Bramford to Twinstead Reinforcement
Planning Inspectorate Reference EN020002

Now that this project has reached the examination stage following acceptance of the application for a Development Consent Order, it is an opportune time to consider some further improvements that would help greatly in appeasing affected residents at minimal extra cost. This is a project that is of particular concern to me as it passes through my ward, including the village I live in (Polstead).

TITLE
 2.11.5 DESIGN AND LAYOUT PLANS: DEDHAM VALE EAST CABLE SEALING END COMPOUND

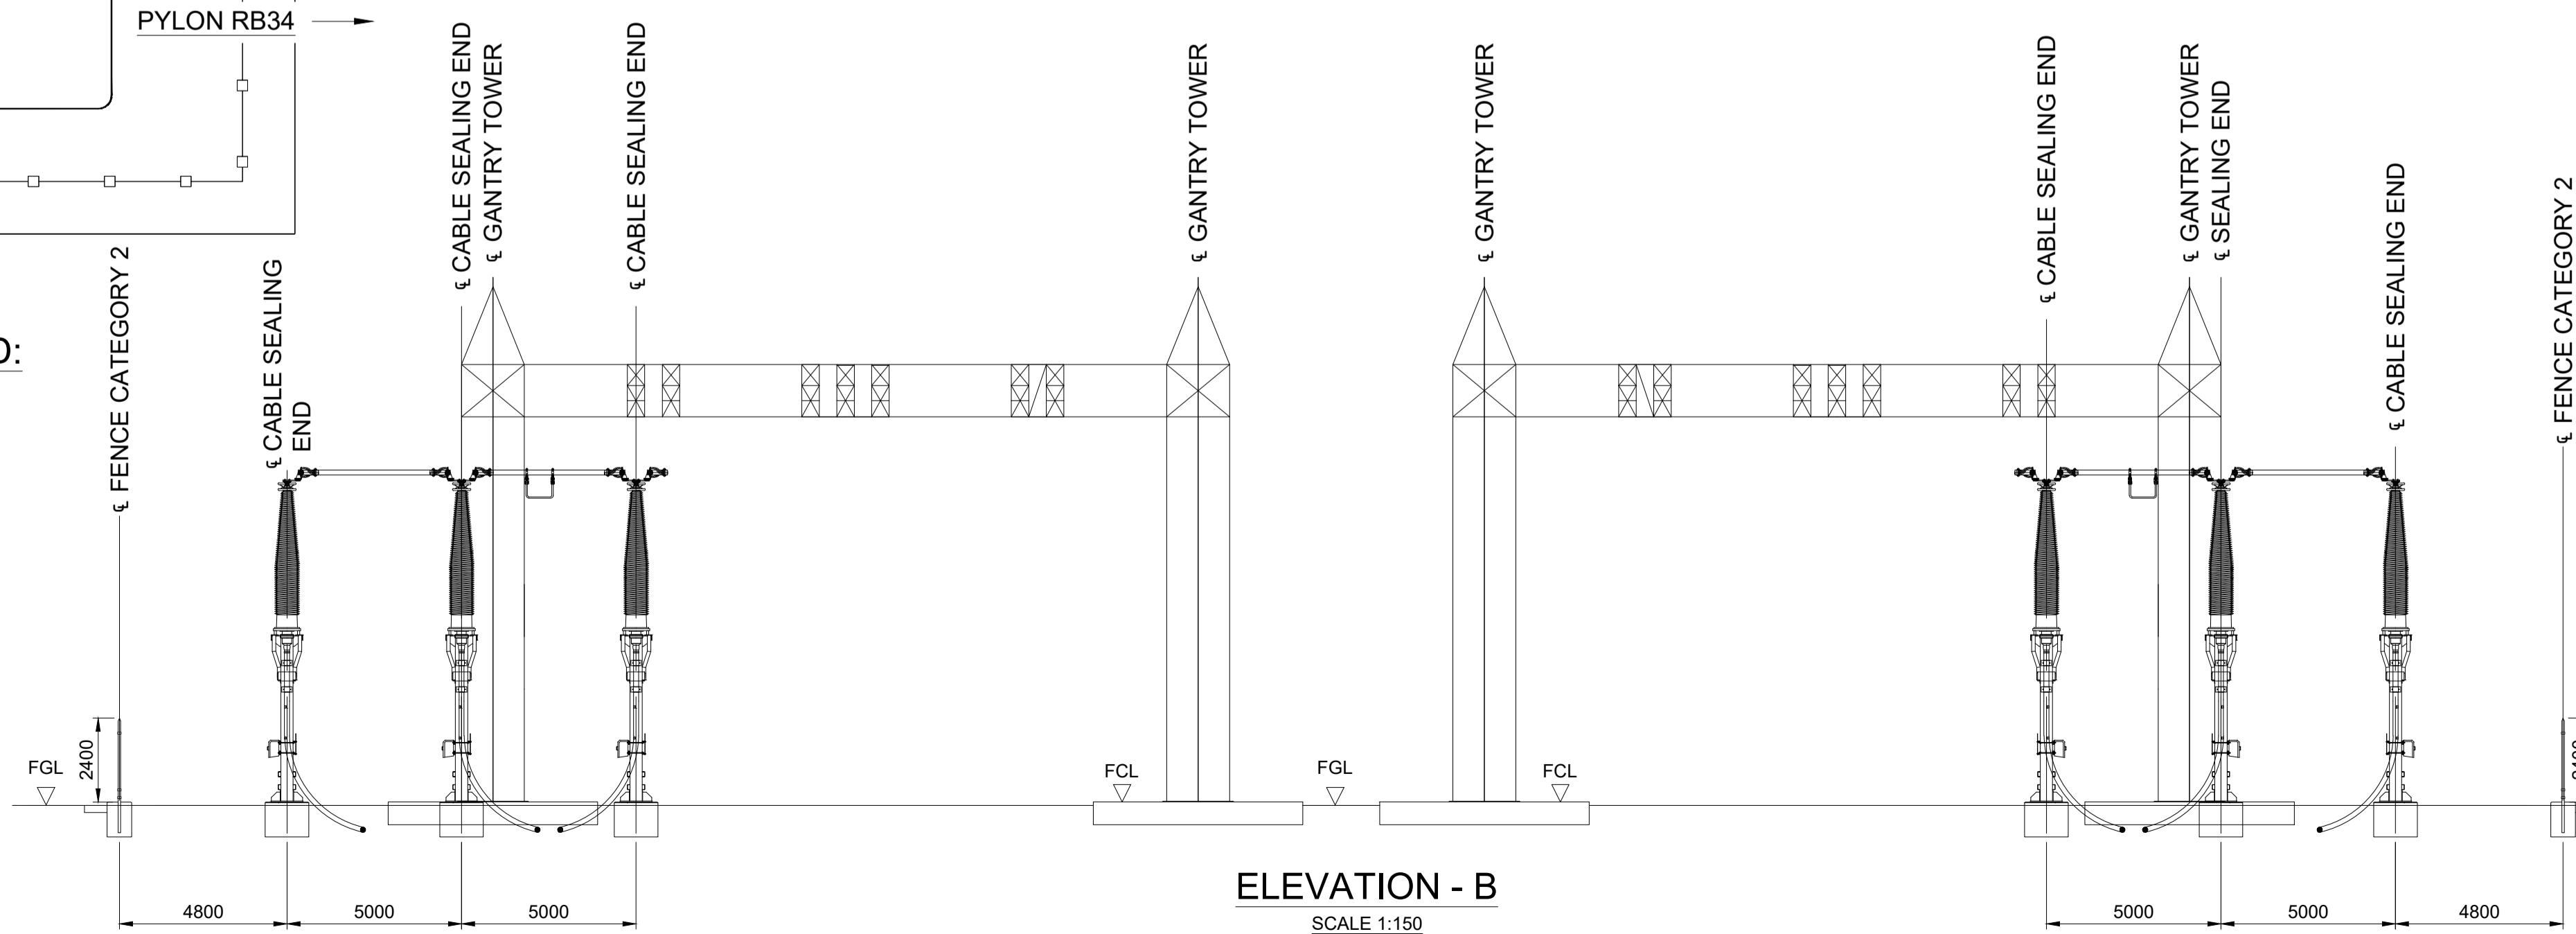
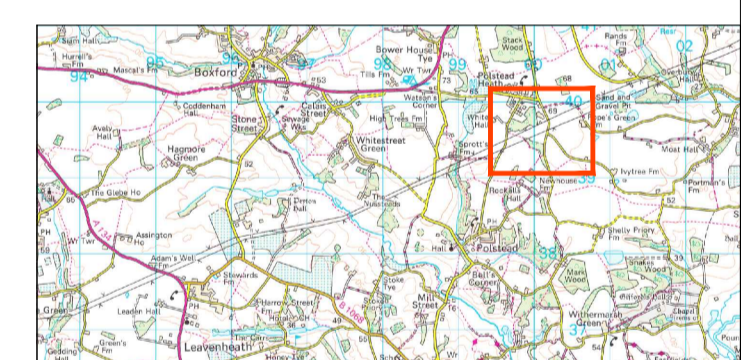
Although it would require an additional 850m of underground route, moving the Dedham Vale East CSE Compound from adjacent to Millwood Road, Polstead, further east to the Layham quarry would ensure that it is in a less visible location and access for construction traffic would be much easier via the existing purpose-built road servicing the quarry. Other correspondents have made submissions that show how this alternative location has significant advantages over the Millwood Road site in every category of the 'Initial Assessment of Principle Issues'. I can only concur with the evidence submitted.

TITLE  
 2.11.7 DESIGN AND LAYOUT PLANS: STOUR VALLEY EAST CABLE SEALING END COMPOUND

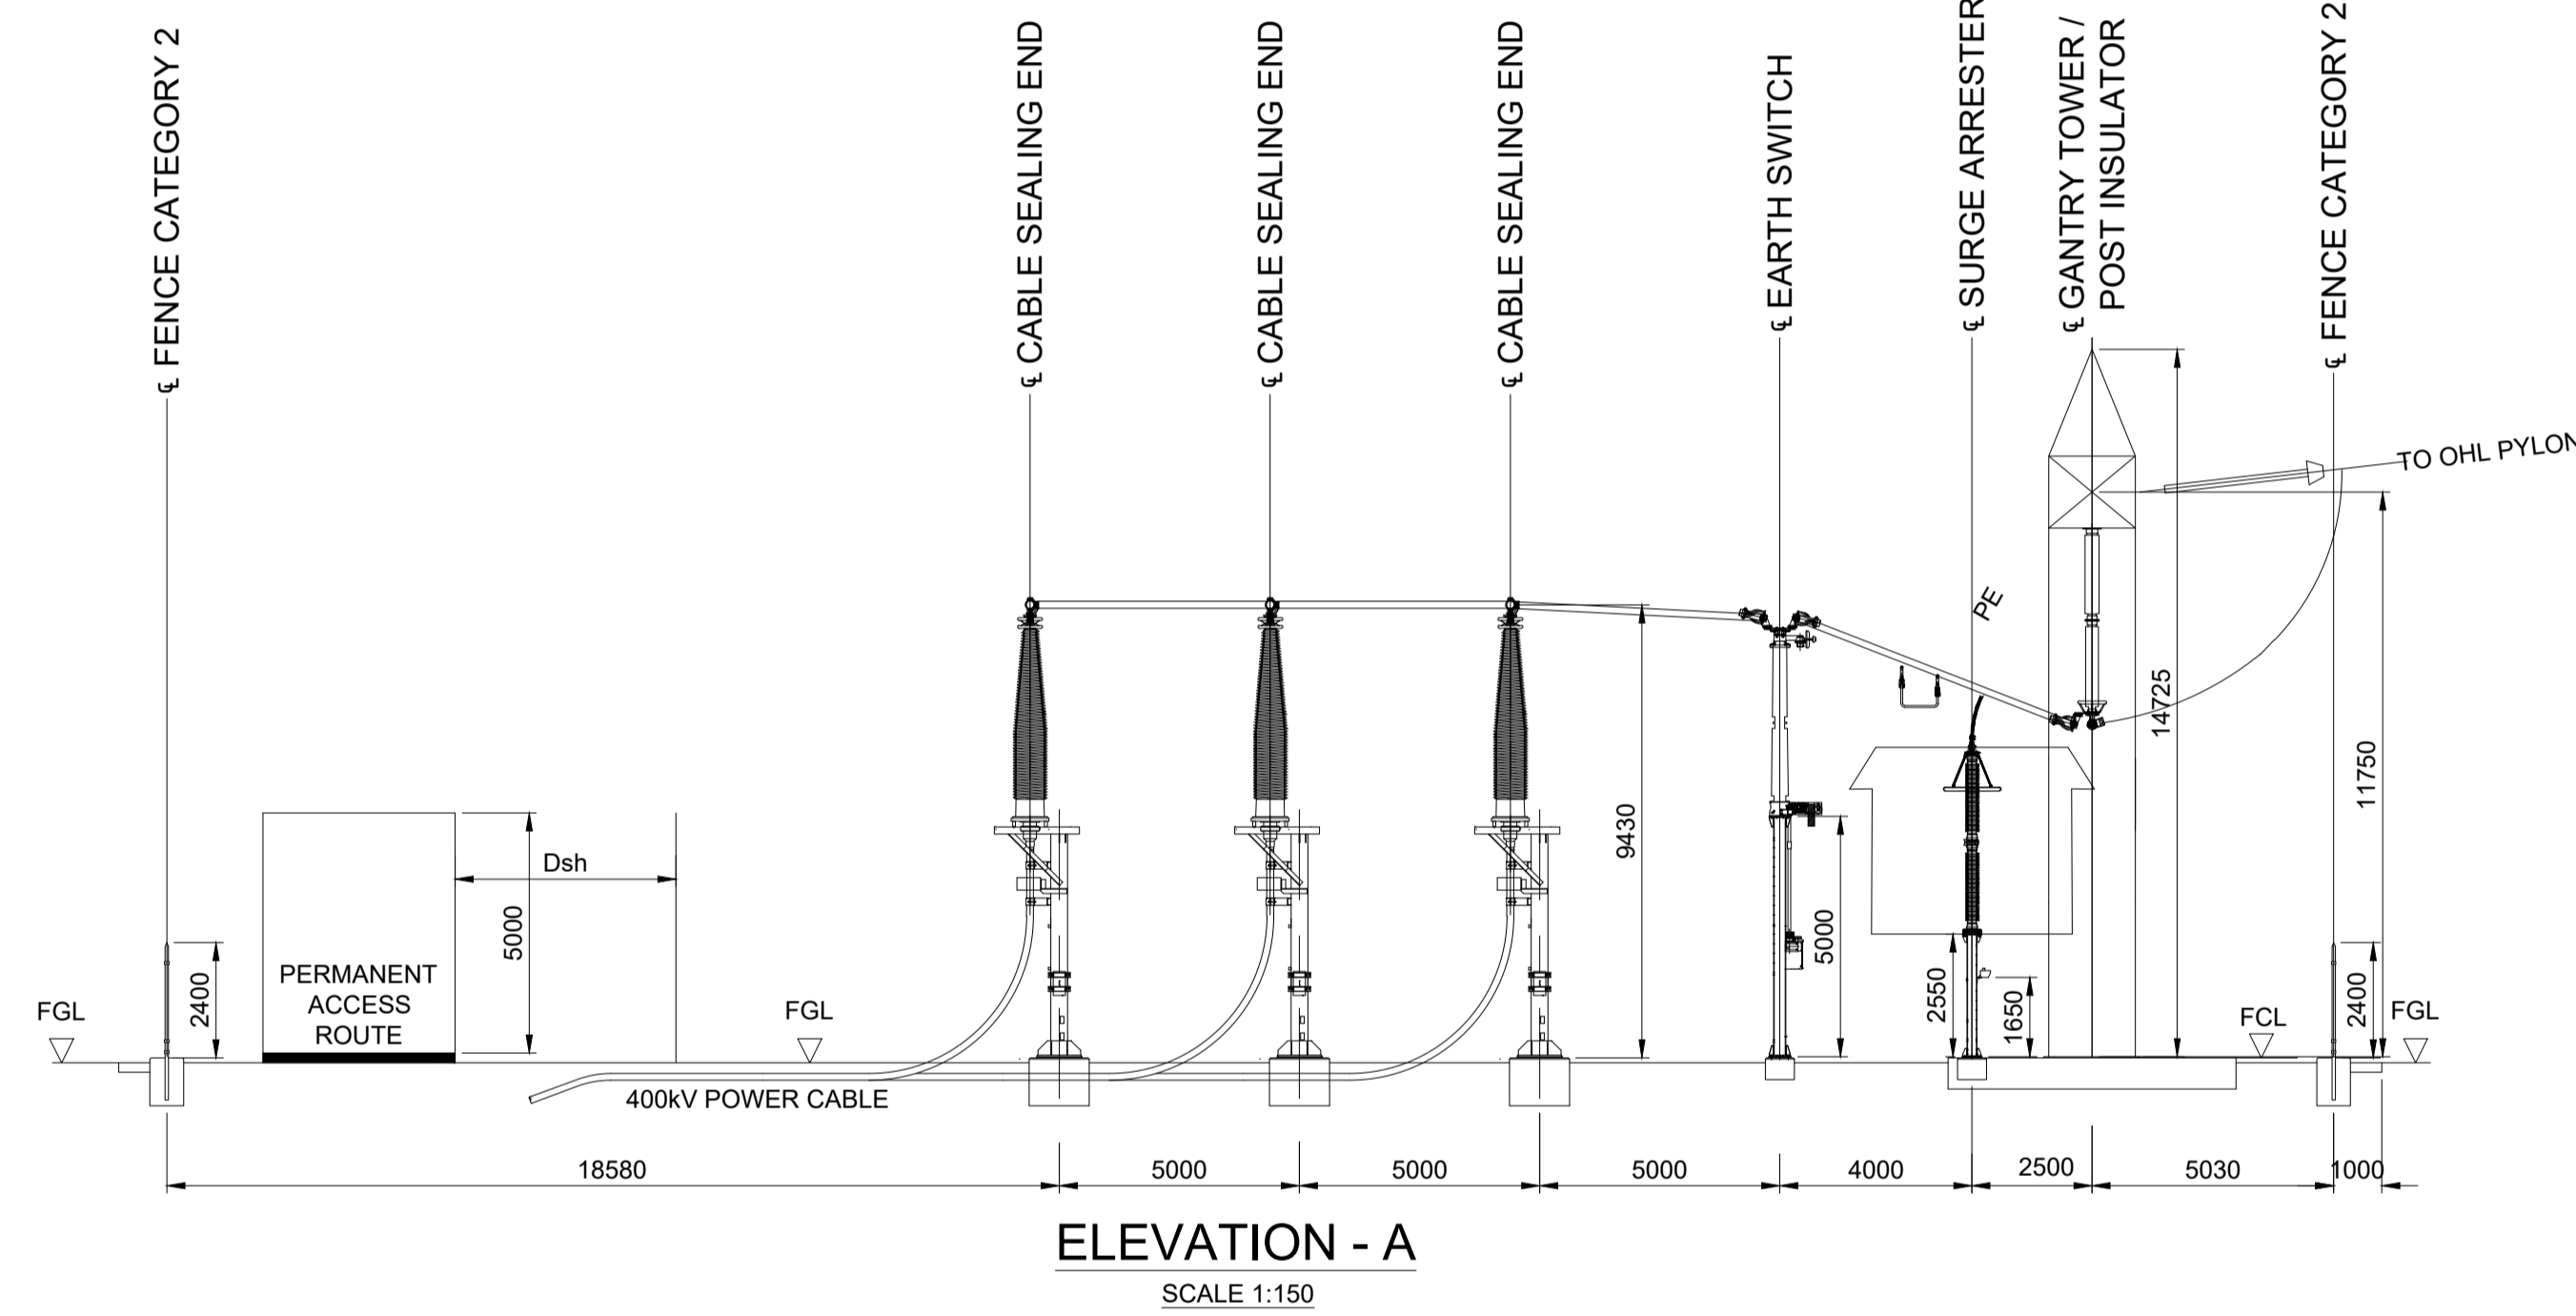
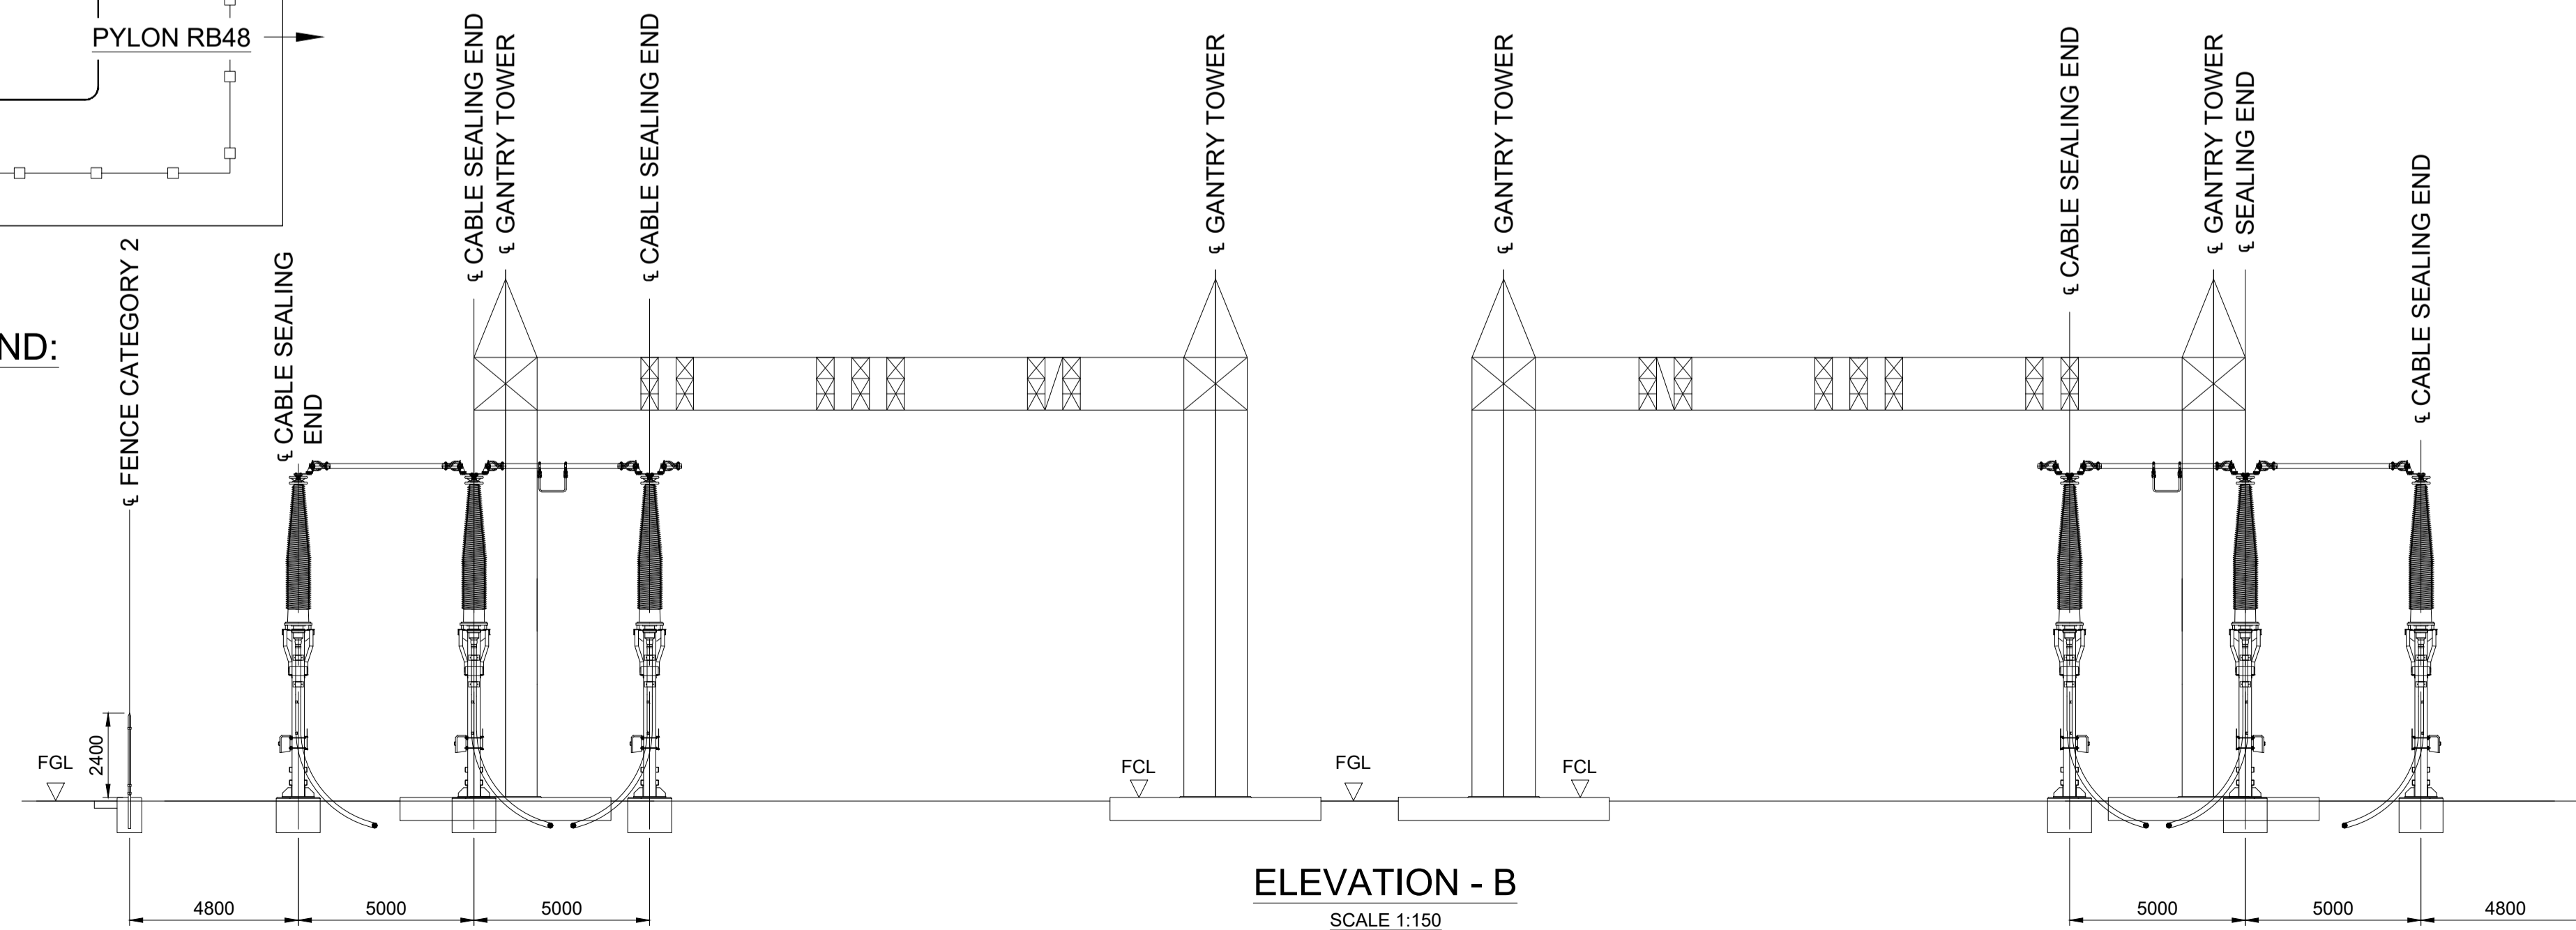
Having an underground link between the proposed underground Stour Valley and Dedham Vale AONB sections would enhance the visual environment as this section, whilst not in the AONB, is still highly visible from many locations within it and the local community would be much happier if this area were to be protected from the visual impact of the pylons. Furthermore, it would obviate the need for two of the four CSE Compounds which, presumably, would offset the cost of the additional underground works.
